REF: 21/02083/REM

Location: Land at Tappers Farm Oxford Road Bodicote

Thank you for consulting me on the above application. I have reviewed the submitted documents and crime statistics for the local area. Whilst I do not wish to object to the current proposals, I make the following comments to ensure that the forthcoming application meets the requirements of;

Proposed planning layout 0737-102

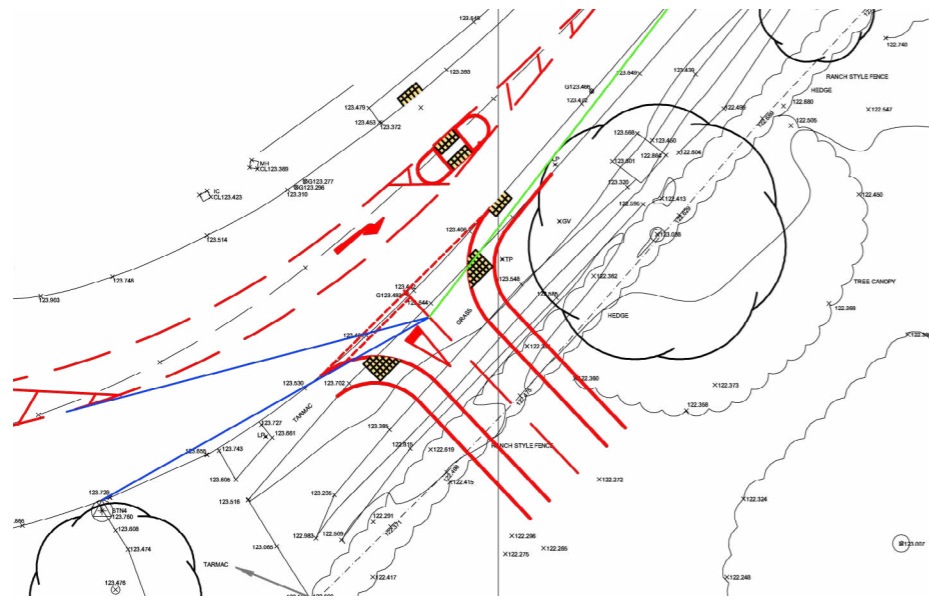
- All rear access routes must be secured with a robust gate of the same height as the boundary treatment, fitted with self-close hinges and key operated lock operable from both sides.
- Rear access routes should be secured as close as possible to the front of the secure building line. I ask that the gates for the rear access to plots 2/3, 7/8, 10/11, 22/23, 25/26 are brought forward as is seen at plot 34 for example.

- All vulnerable side and rear boundaries that adjoin the public realm must be provided with defensible space and planting to provide suitable standoff and demarcation of the change from public to private realm. I ask that defensible space and planting is added to the side wall of plots 25, 30, 31, 37.
- I have concerns that the parking arrangements for plot 30 creates an ambiguous area to the rear of plots 30 and 31, which creates a recessed area and hiding places, leaving the rear boundaries of these two plots vulnerable. This concern is exacerbated by the fact this area is not lit, and the rear boundary will create a pool of shadowing in this area. I ask that this space is revised to remove the irregular parking arrangement and subsequent dead space and incorporate defensible space as per the point above.

- I ask that an extra window is provided in the dining room/lounge of plots 45/46 to increase surveillance over the green POS.
- I ask that an extra window is provided in the lounge of plots 45/46 to increase surveillance over the parking area and POS.
- An extra window needs to be added to the blank elevation of plot 39, overlooking the parking and footpath.
- An extra window should be added to the blank elevations of plot 36/37 which overlook the public realm.
- I ask that the size of the first floor living room window for plot 3-6 is increased to match the ground floor window, increasing surveillance over the LAP and POS.
